**Re: Section 96 Application for SSD 5204 – Redevelopment of Tamworth Hospital**

In December 2012, the Minister's delegate approved the redevelopment of Tamworth Hospital. Since that time a number of minor changes have been required to finalise the proposed development. While these changes are minor, HI requests that an amendment in accordance with Section 96(1A) be determined to recognise the changes proposed.

PROJECT
TAMWORTH HEALTH SERVICE REDEVELOPMENT
DEAN STREET, TAMWORTH NSW 2340
DRAWING NAME
South Elevation
ZONE
E
PHASE
DD
SCALE
1:200
AT
A0 SIZE
MASTER SITE No
CLIENT REF No
DRAWING NUMBER
SSD-AR-NZ-00-04114
REVISION
5
SHEET No

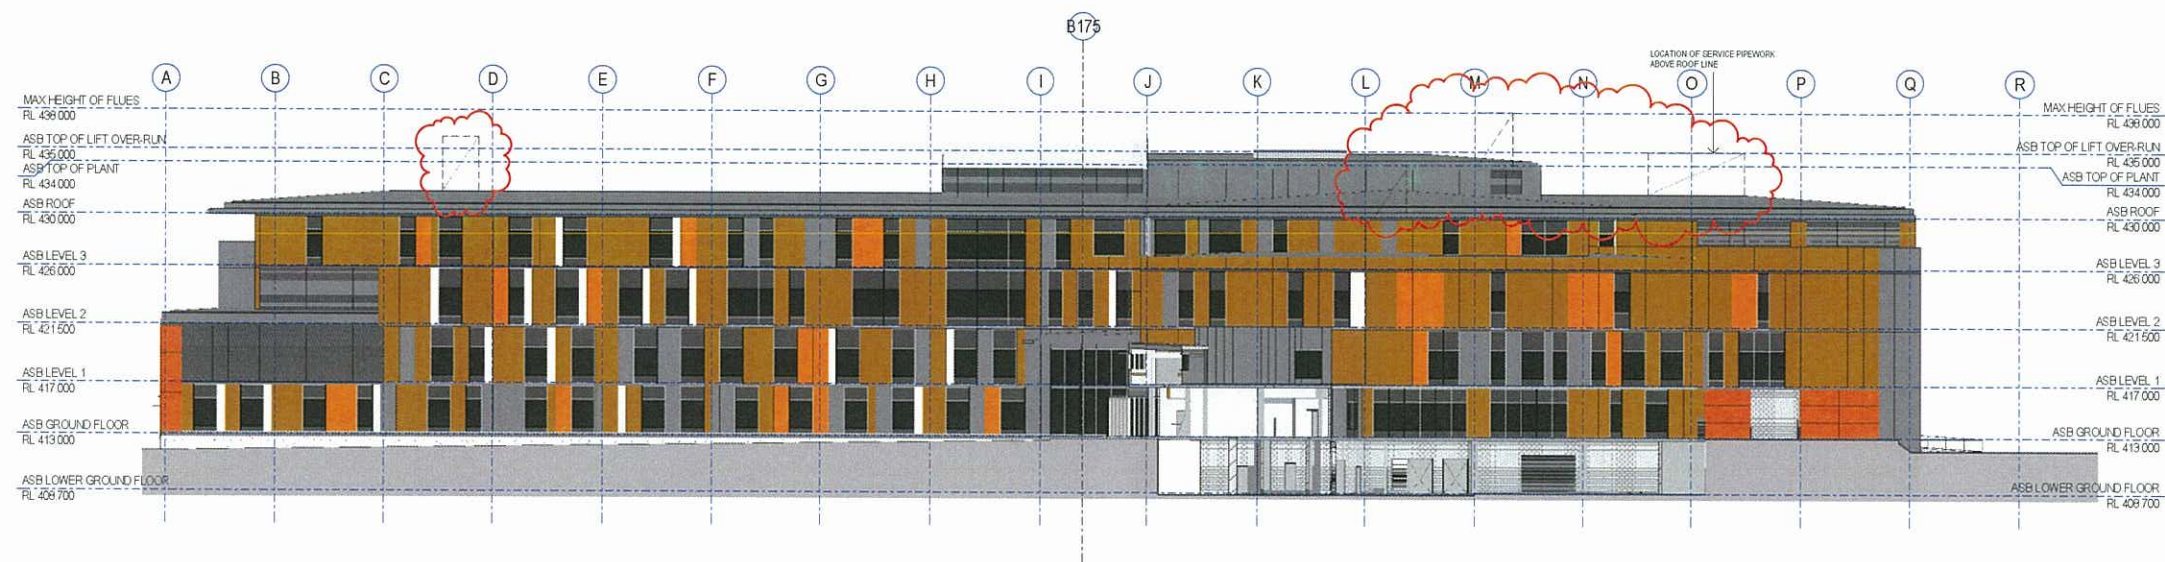
The approved plans note that the wall cladding will be Alpolic®, which is a specific brand of metal composite cladding. Following further detailed design the material to be used will not be Alpolic® branded product but rather a generic metal composite Product. There will be no change to the colours proposed.

PROJECT
TAMWORTH HEALTH SERVICE REDEVELOPMENT
DEAN STREET, TAMWORTH NSW 2340
DRAWING NAME
AREA PLAN - ROOF
FL 430.000

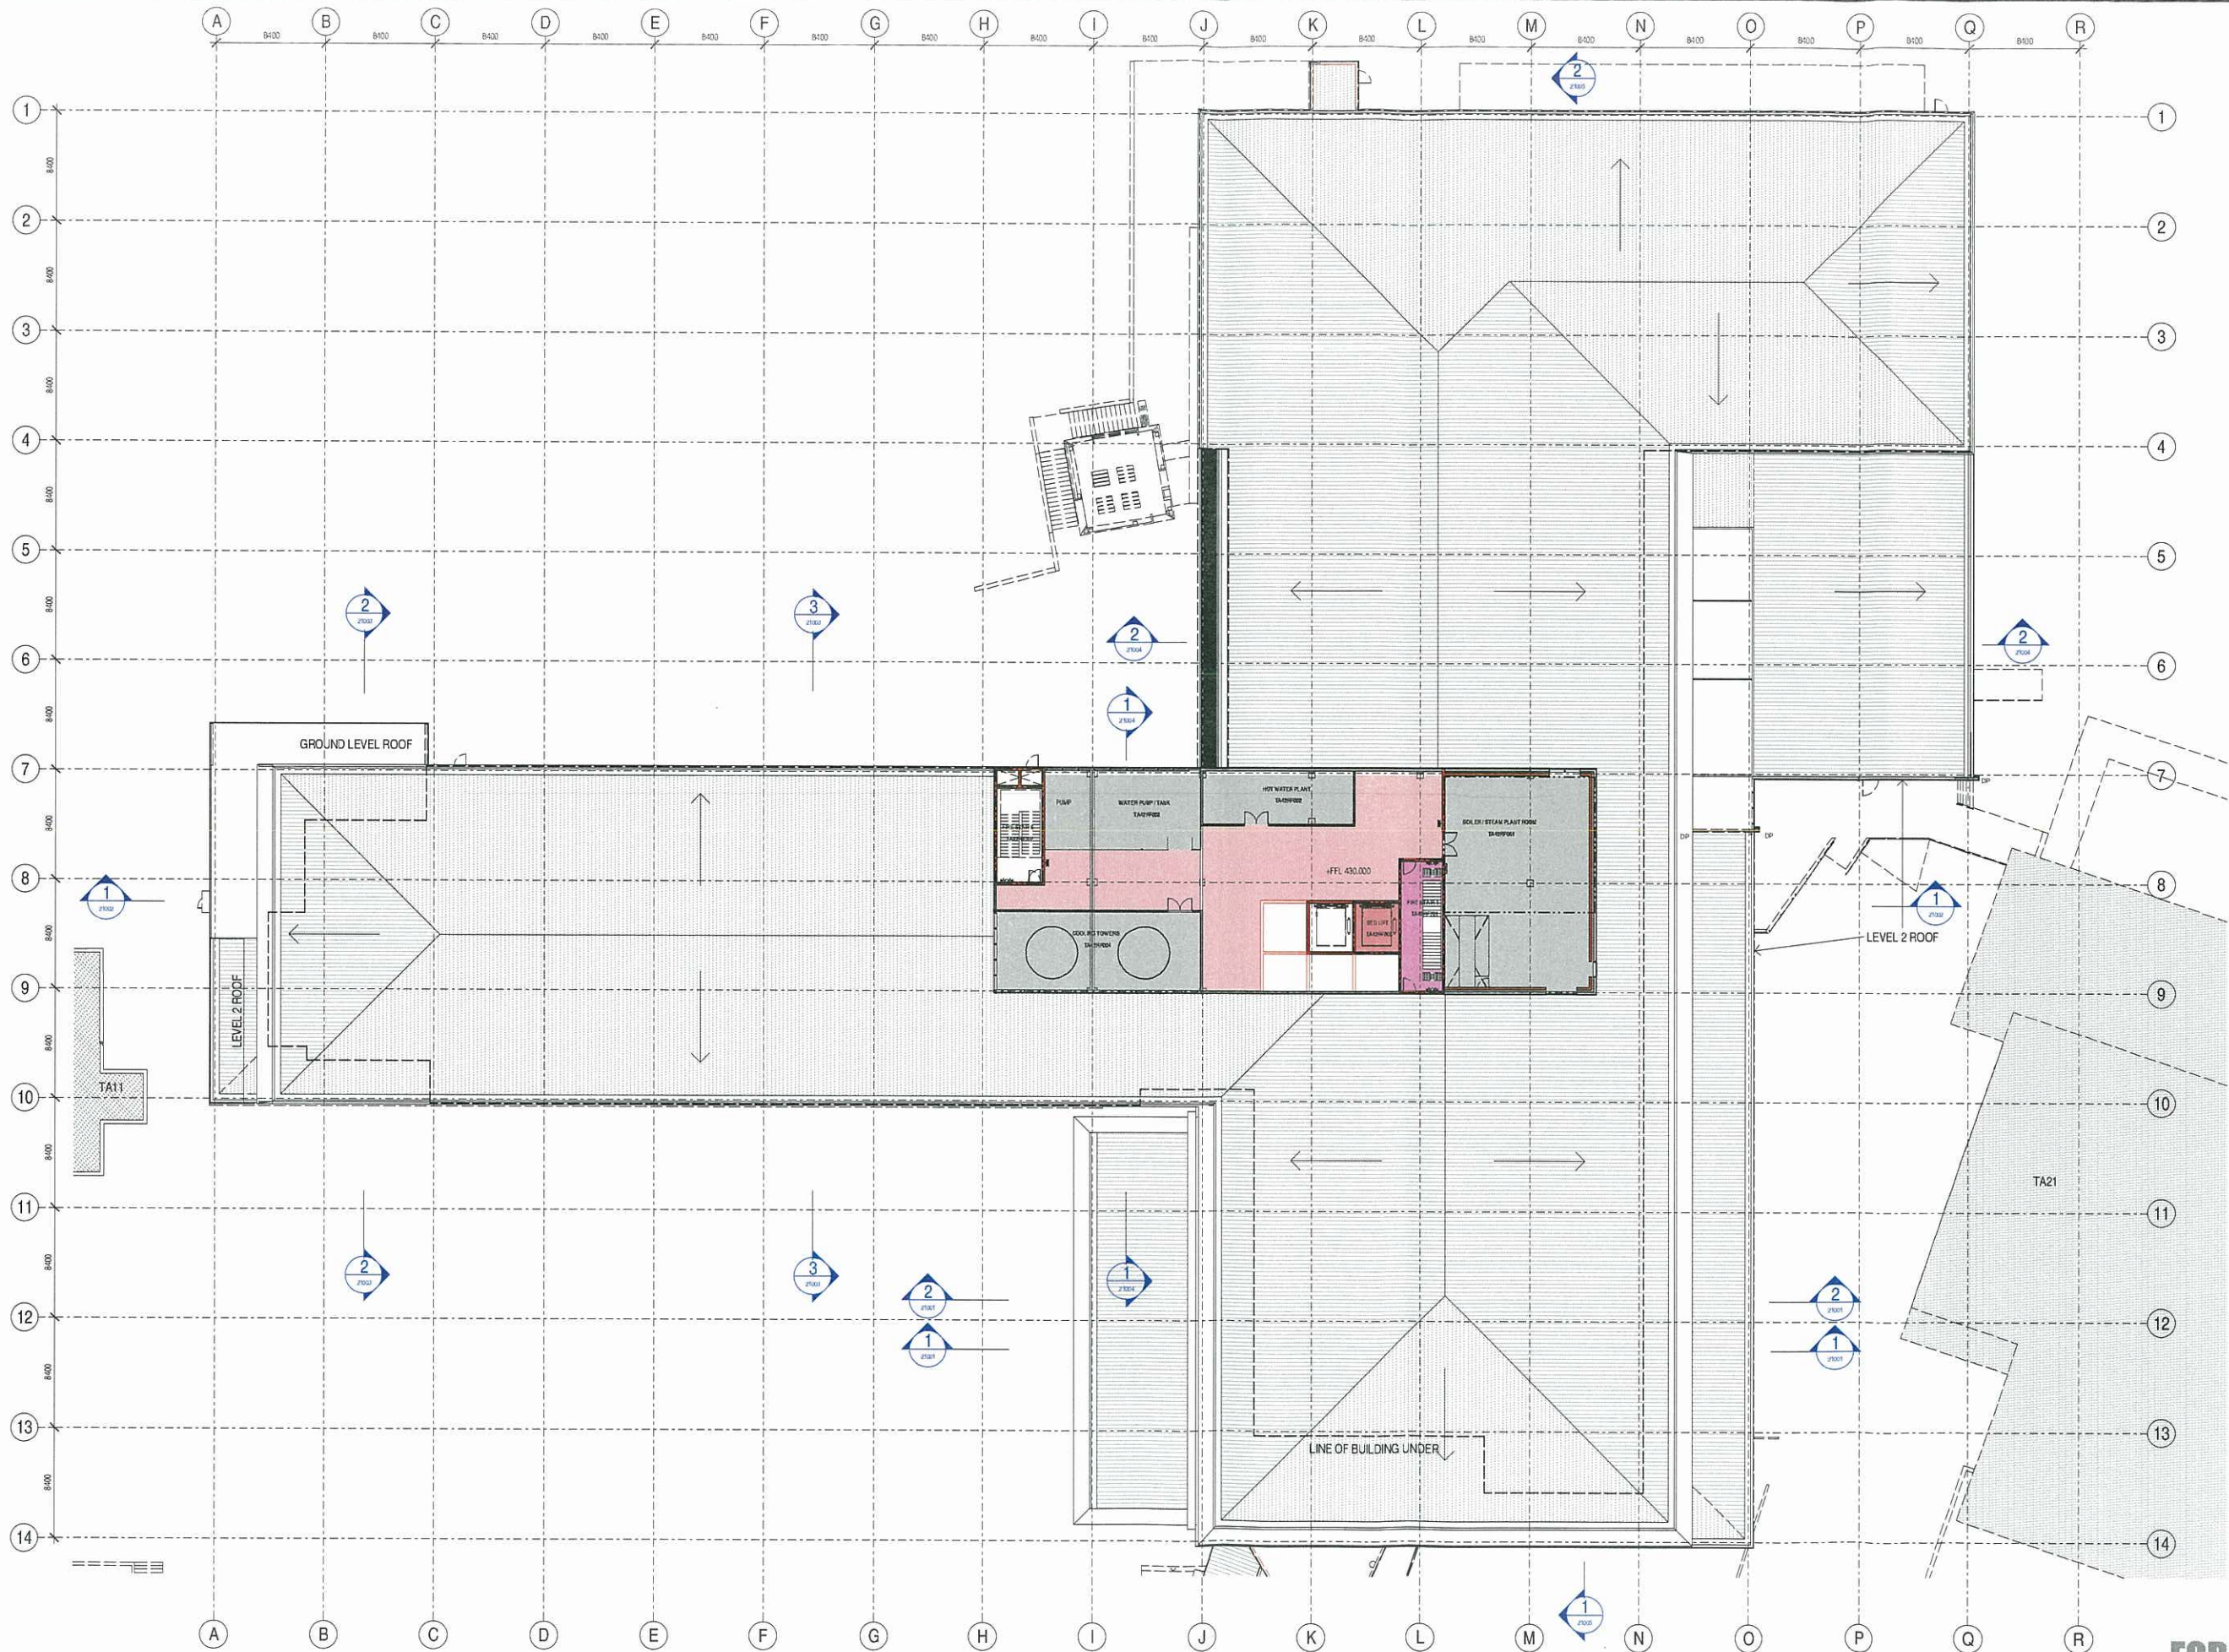
As a result of detailed building planning, a reorientation of the roof top plant has been required. With this reorientation the plant room now includes the circulation spaces which were originally proposed to be external. This has increased the size of the plant room to 515sqm from the approved 165sqm. In addition, the reconfiguration has necessitated changes to height in small areas of the building as follows:

1. The top of the plant room will increase in height from RL433.00 to 434.00 (a one metre increase over the extent of the plant room.
2. The lift overrun on the roof of the building has increased from RL 433.00 to 435.00 (2 metres above the roof height approved) for the area of the lift overrun only.
3. The mechanical flues are located at RL 438.00 - 5 metres above the approved height of the building for the small area where the flues are located.

Drawing Name
Landscape Masterplan

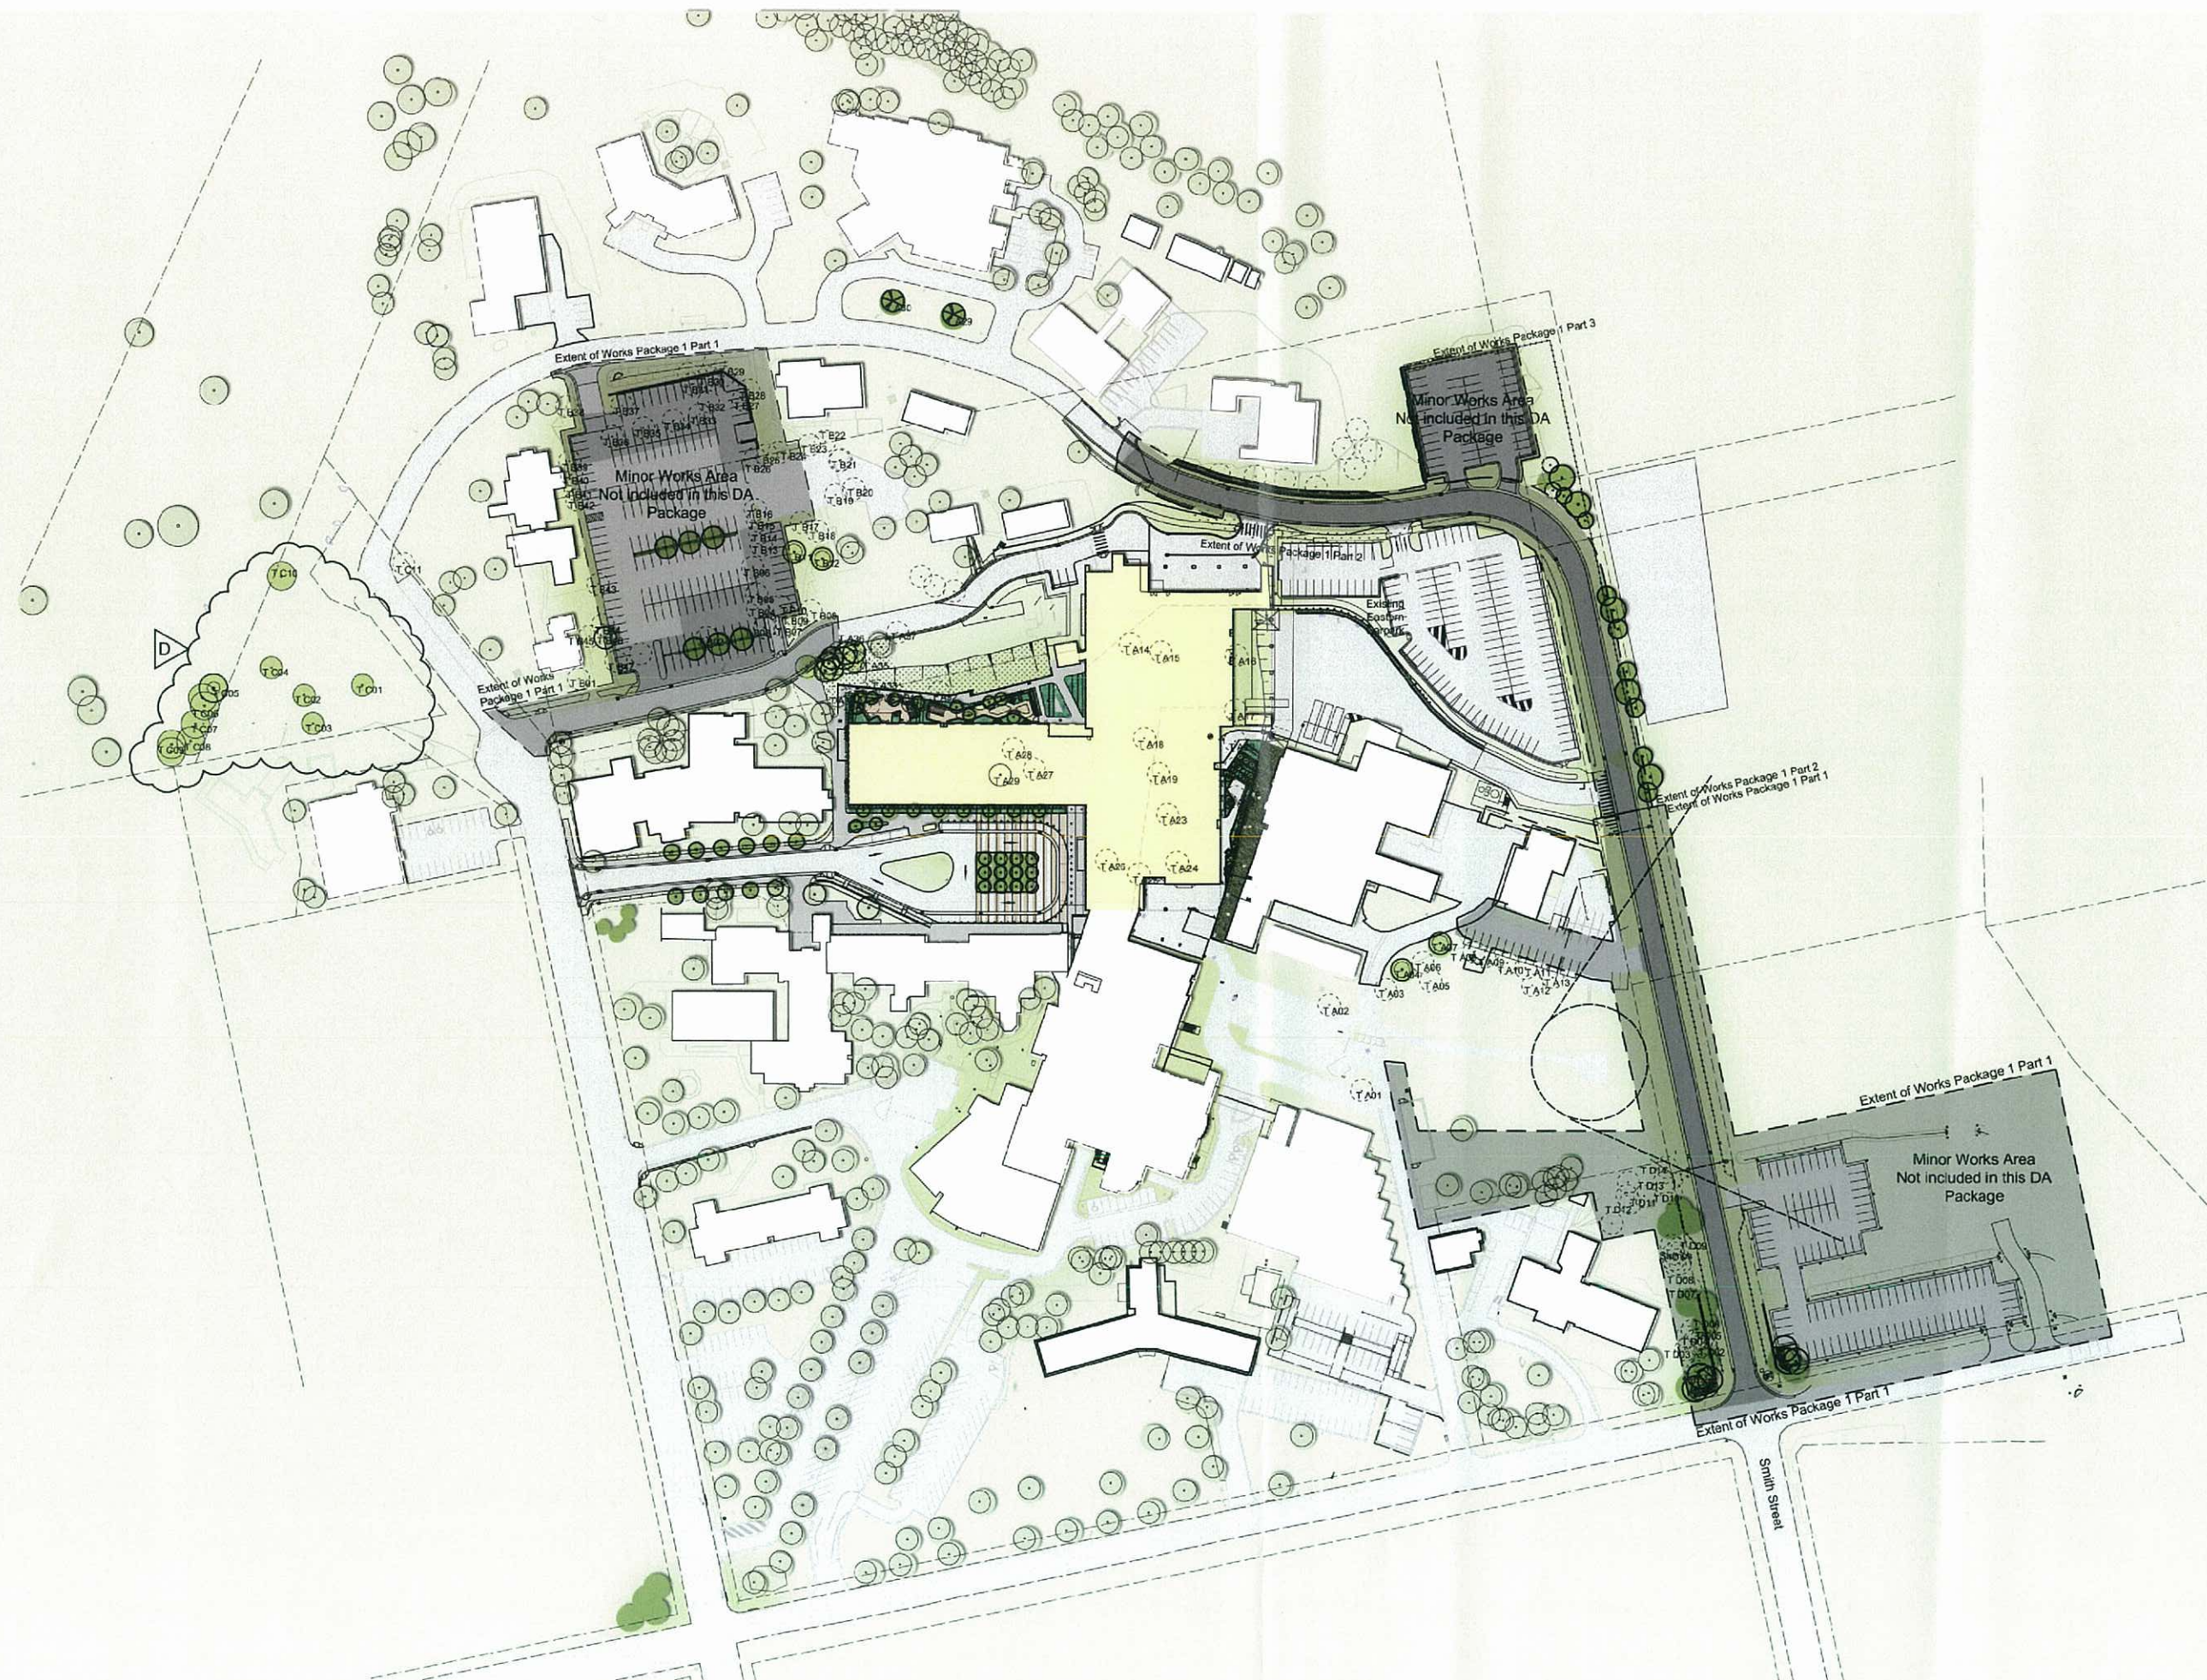
There are two slight changes in the landscaping proposed. The first of these is the lowering of the landscape in the entry area of the hospital. The approved plans showed tree planting in the road median, however subsequent safety analysis has indicated that this arrangement poses a safety risk due to a lack of through sight lines. It is therefore proposed to remove planting to allow sight lines in this location. The trees will be replaced with turf.

The second amendment is the location of the trees transplanted from the building footprint. Trees #18 and 29 have been transplanted into the northern loop road adjacent to the Banksia Mental Health Unit as shown on the revised Landscape Masterplan.
